Response to Planning Application

Application ref: Y/71/20/RES

Description: Approval of reserved matters following outline consent Y/88/18/OUT for the erection of 38 No. dwellings

Location: Land North of Yapton Church of England Primary School North End Road Yapton

DRAWING FILE LOCATION:
Z:\Dropbox (Deacon Design)\151\03 PROJECTS 400\DD427_Land At Stakers Farm, Yapton\04-Drawings\AutoCAD\Landscape Design\DD427L01-02_Landscape General Arrangement Plan.dwg

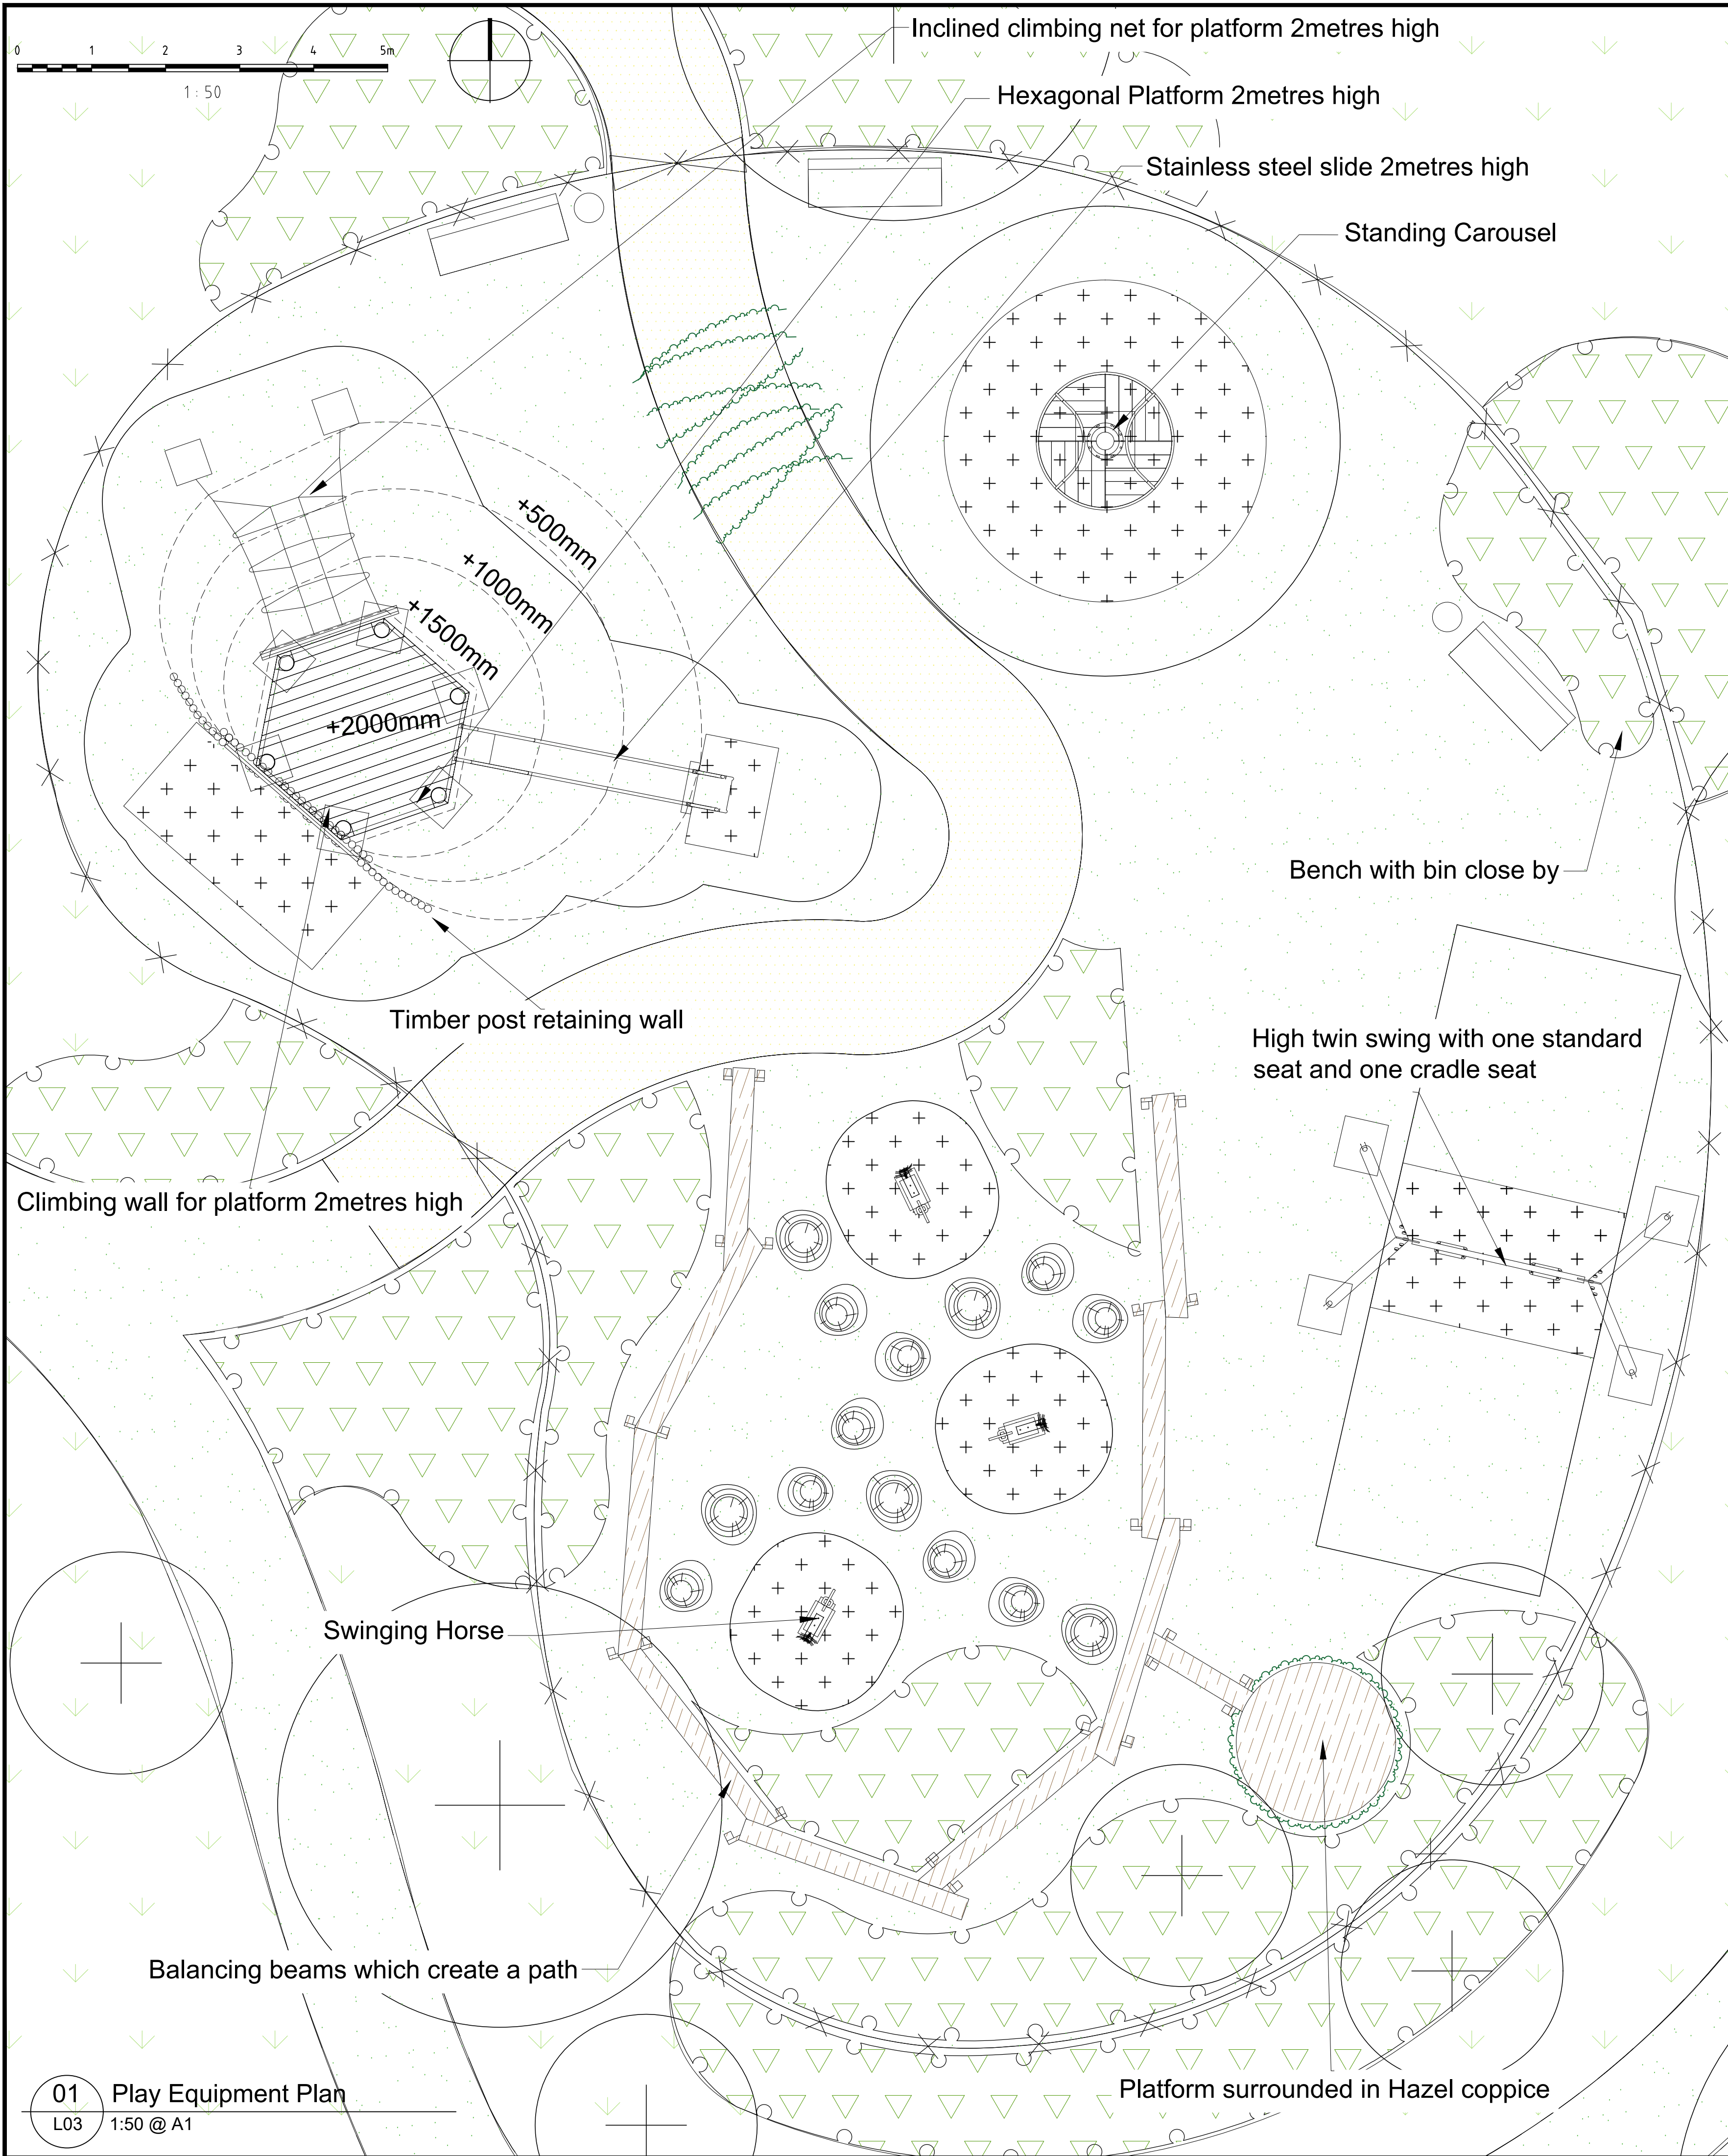
- Clarification re the Parish requested DDA compliant footway and PRow within the site and its connectivity beyond the site. It is not clear if this pathway has been afforded the stated buffer zone? And how it links to the adjacent development of Clays Farm? The drawings at present do not show a joined up network of pathways and the north/east connection appears to run over a grassed area and to a detailed close board fence without connectivity through. It is also unclear of how the pathway adjoins North End Road. It is also stated in the drawings that the pathway through the POS are to be 'hoggin' pathways? This may not be classified as a suitable DDA compliant surfacing and attracts maintenance issued in highly trafficked areas. Tarmac pathways would be more suitable for this purpose.

- Layout – It is a shame that the dwellings that sit at the entrance to North End Road face side on, therefore giving a view of side fences at the entrance to this site from North End Road. Planting along this entrance has been setback to allow for sightlines however as an entrance the present layout could be much improved.

- The POS in this section appears to be an open green area which is satisfactory, in light of the LEAP offer being provided in the southern adjoining parcel of development. It does however indicate logs and seating, clarification be sought regarding the formality of this and if this is shown as a LAP?

DRAWING NUMBER :	REVISION LETTER :
DD427L05	B

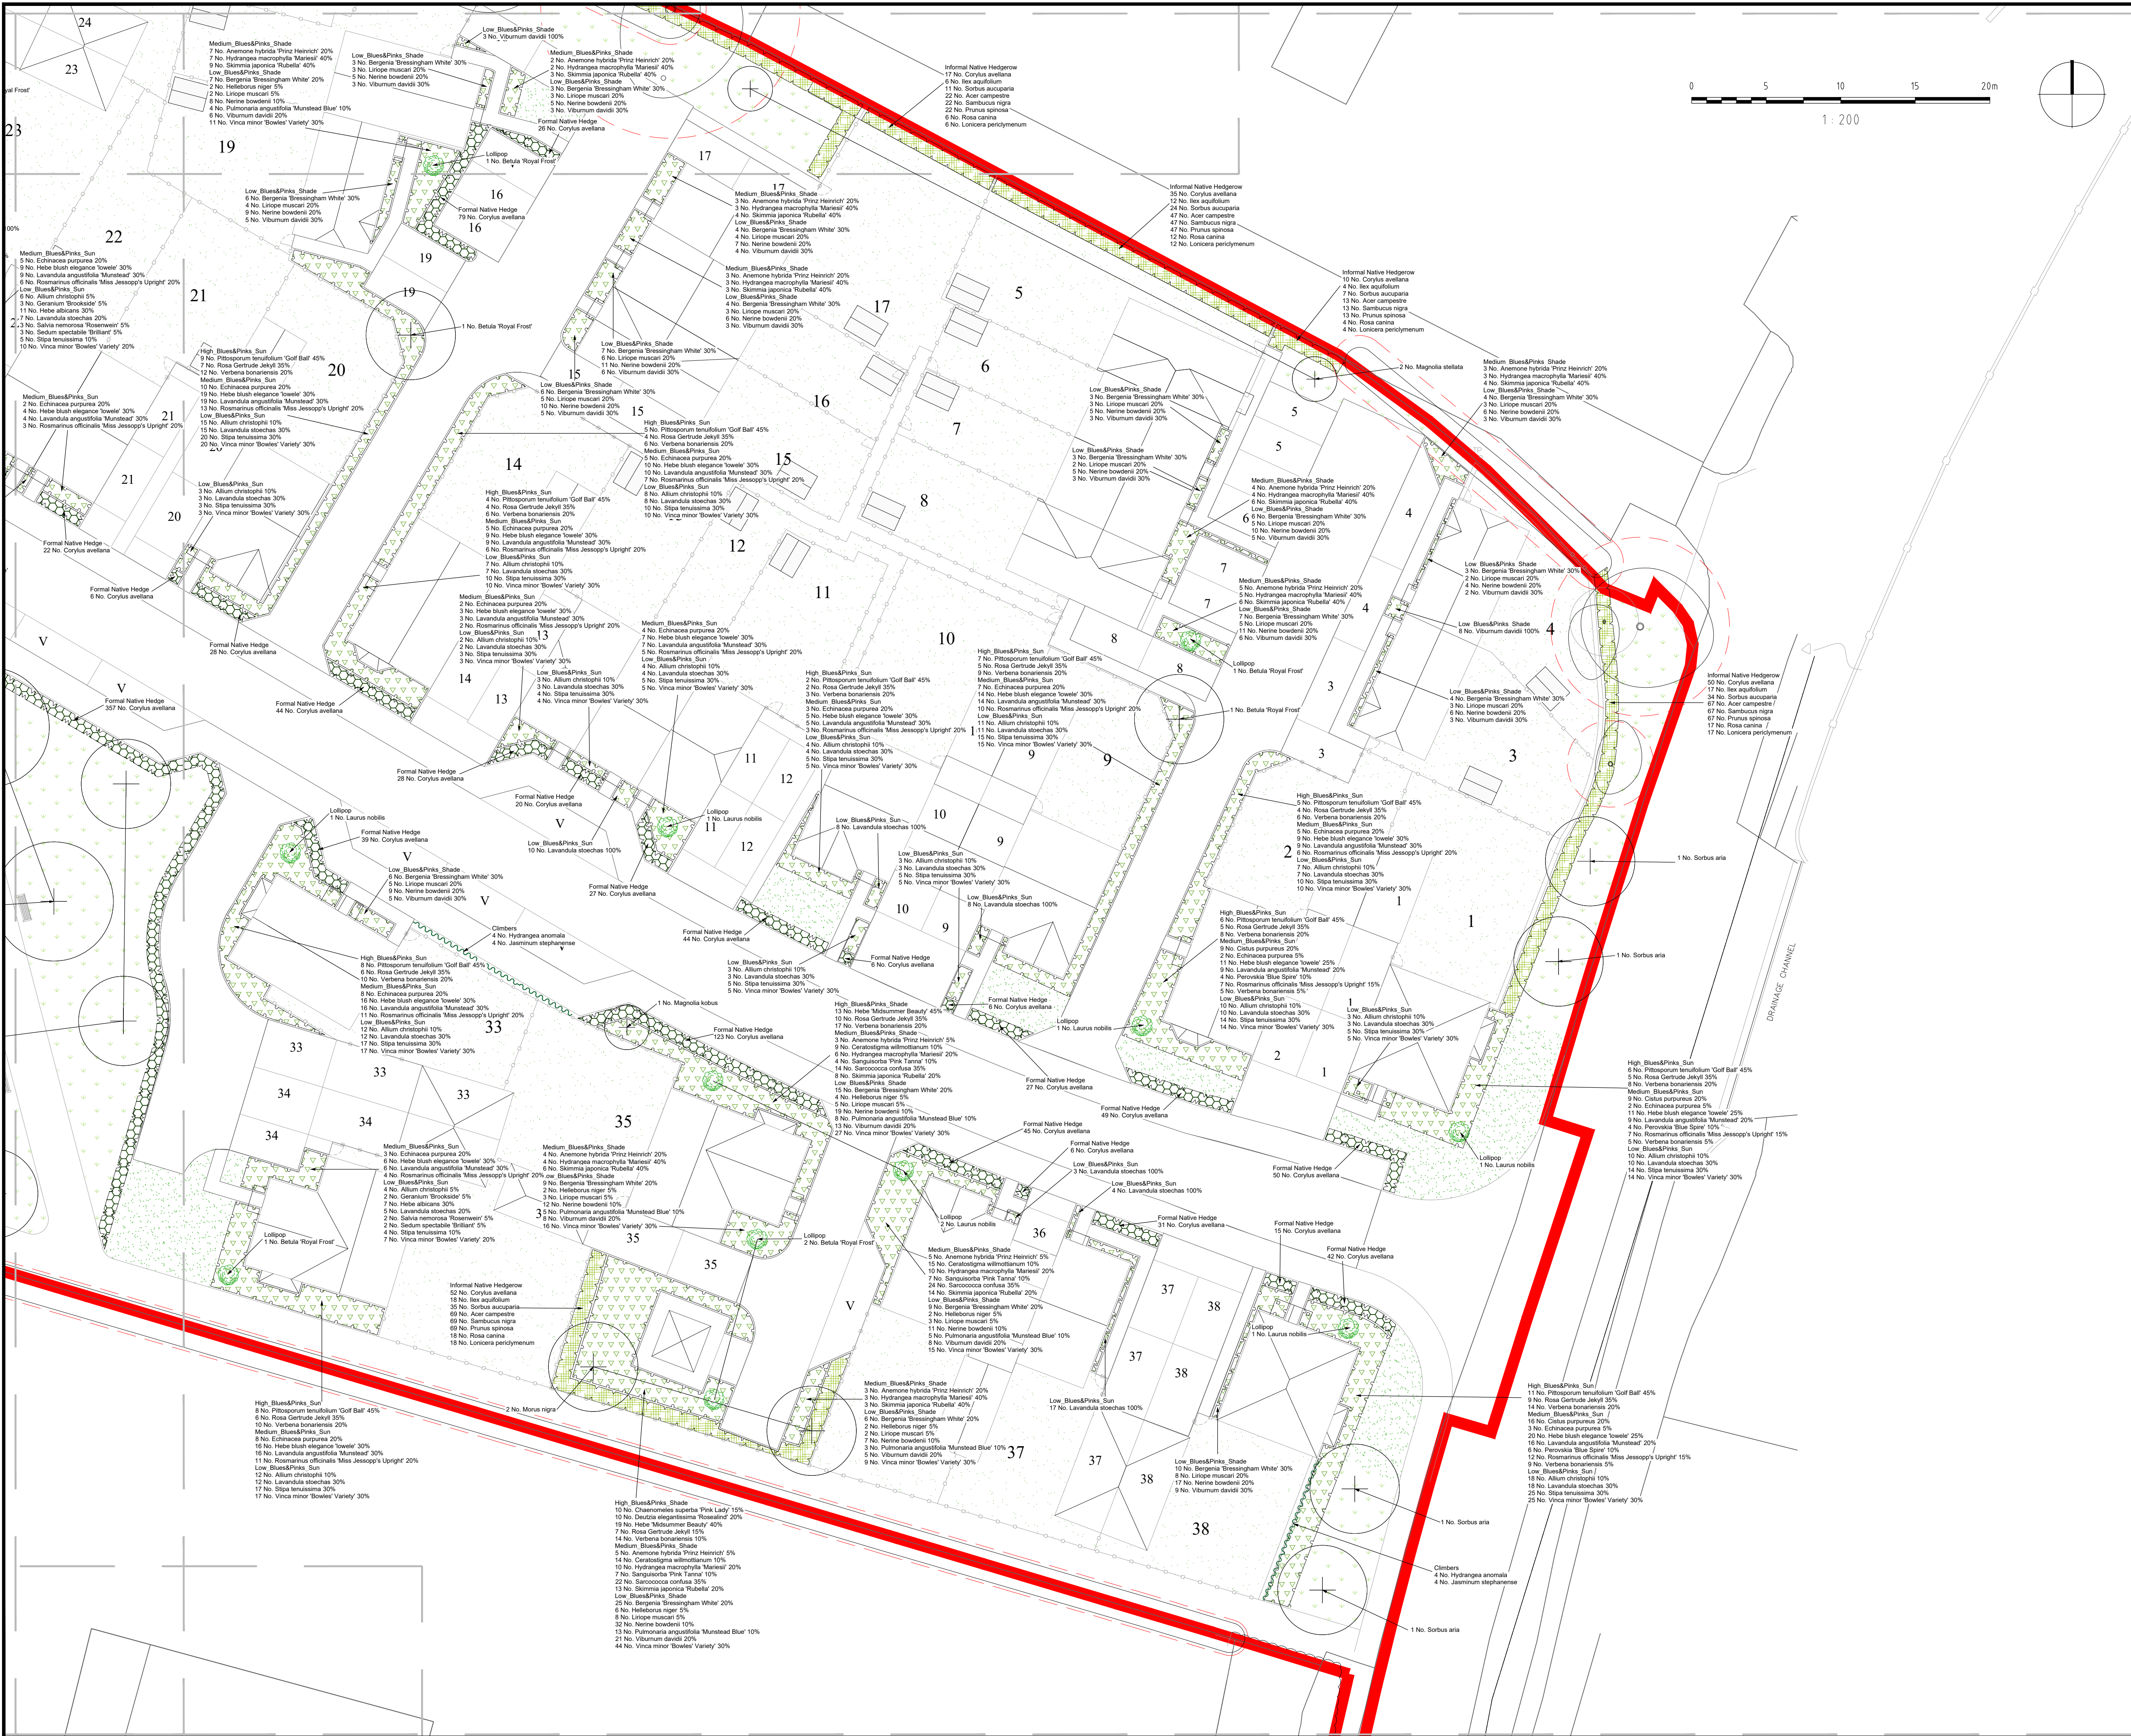
In general the detailed landscape proposals have shown a scheme which would be fitting for location in species choice, planting densities and size at time of planting. Given adequate maintenance these proposals should mature to form a scheme which is fitting for location and enhances the setting of the development. I would however raise for clarification the following points:
